DECISION DELEGATED TO DEVELOPMENT MANAGER

Application No: H23-0379-21 **Applicant:** Mr R Mills

Proposal: Proposed 4 bed dwelling and car port - approved under H23-0470-19. Modification of Condition 2 to allow amendments to previously approved plans

Location: Ferndale House Dowsdale Bank Shepeau Stow

Proposed Elevations			
Project number	2021	P101	Scale 1 : 100
Date	11.03.2021		
Drawn by	RG		
Paper	A3

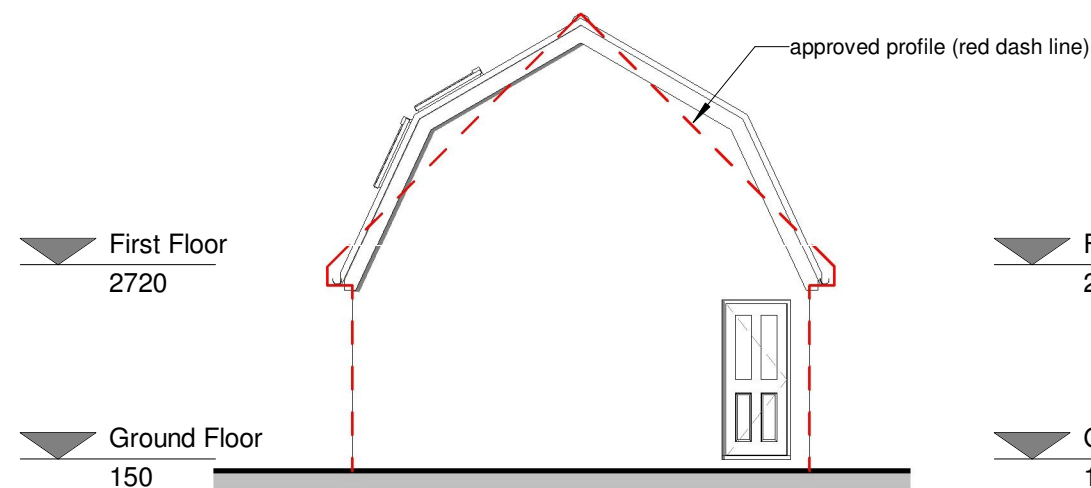
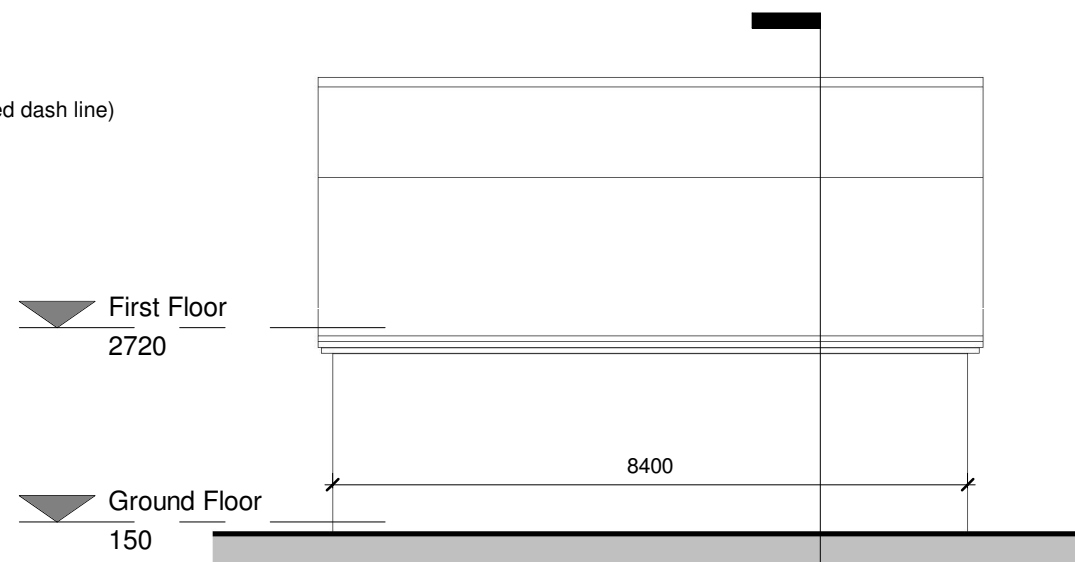
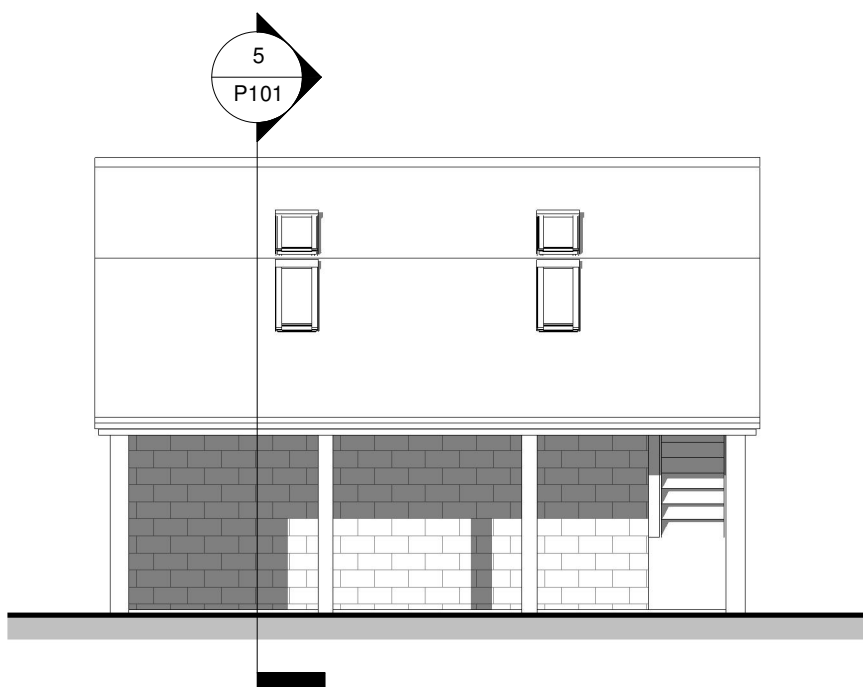
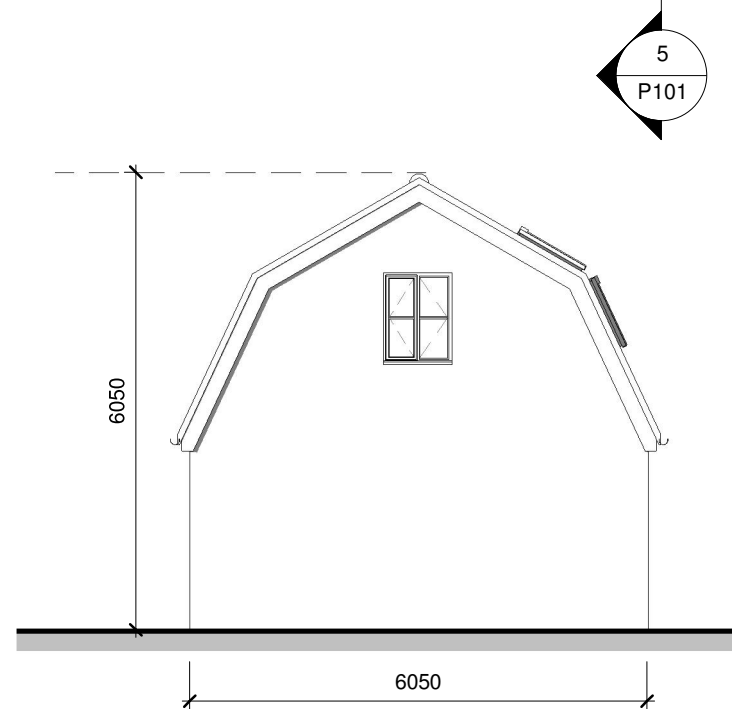
The site has full planning permission for a 4 bed chalet type dwelling and detached car port within the front garden area (ref. H23-0470-19). This application is to amend the design of the detached garage (see information from applicant's agent). The main alterations are the replacement of the pitched roof with a gambrel (Dutch) roof and introduction of roof lights on the southern elevation.

Building at least twice the height of the original proposal; Believe it will be used as a residence and have a big impact on parking on which is already a dangerous road.

No alterations are proposed to the design of the 4 bed chalet type dwelling. The main alterations to the detached car port within the front garden area are the replacement of the pitched roof with a gambrel roof and introduction of roof lights on the southern elevation. The garage would have a height of some 6.05 metres, which is approximately the same as previously approved. Given the varied nature of existing development in terms of design and building line it is considered that the proposed development would not appear unduly incongruous within the rural street scene and would not materially harm the character/appearance of the rural locality.

The design of the dwelling remains the same as previously. The revised garage includes roof lights on the southern elevation. However, they are approximately 12 metres from the neighbouring front garden to the south (Arabia). It is considered that amenity of neighbouring residents would not be materially harmed in terms of overlooking, lack of privacy, overbearing effect, blockage of light, noise and disturbance, etc.
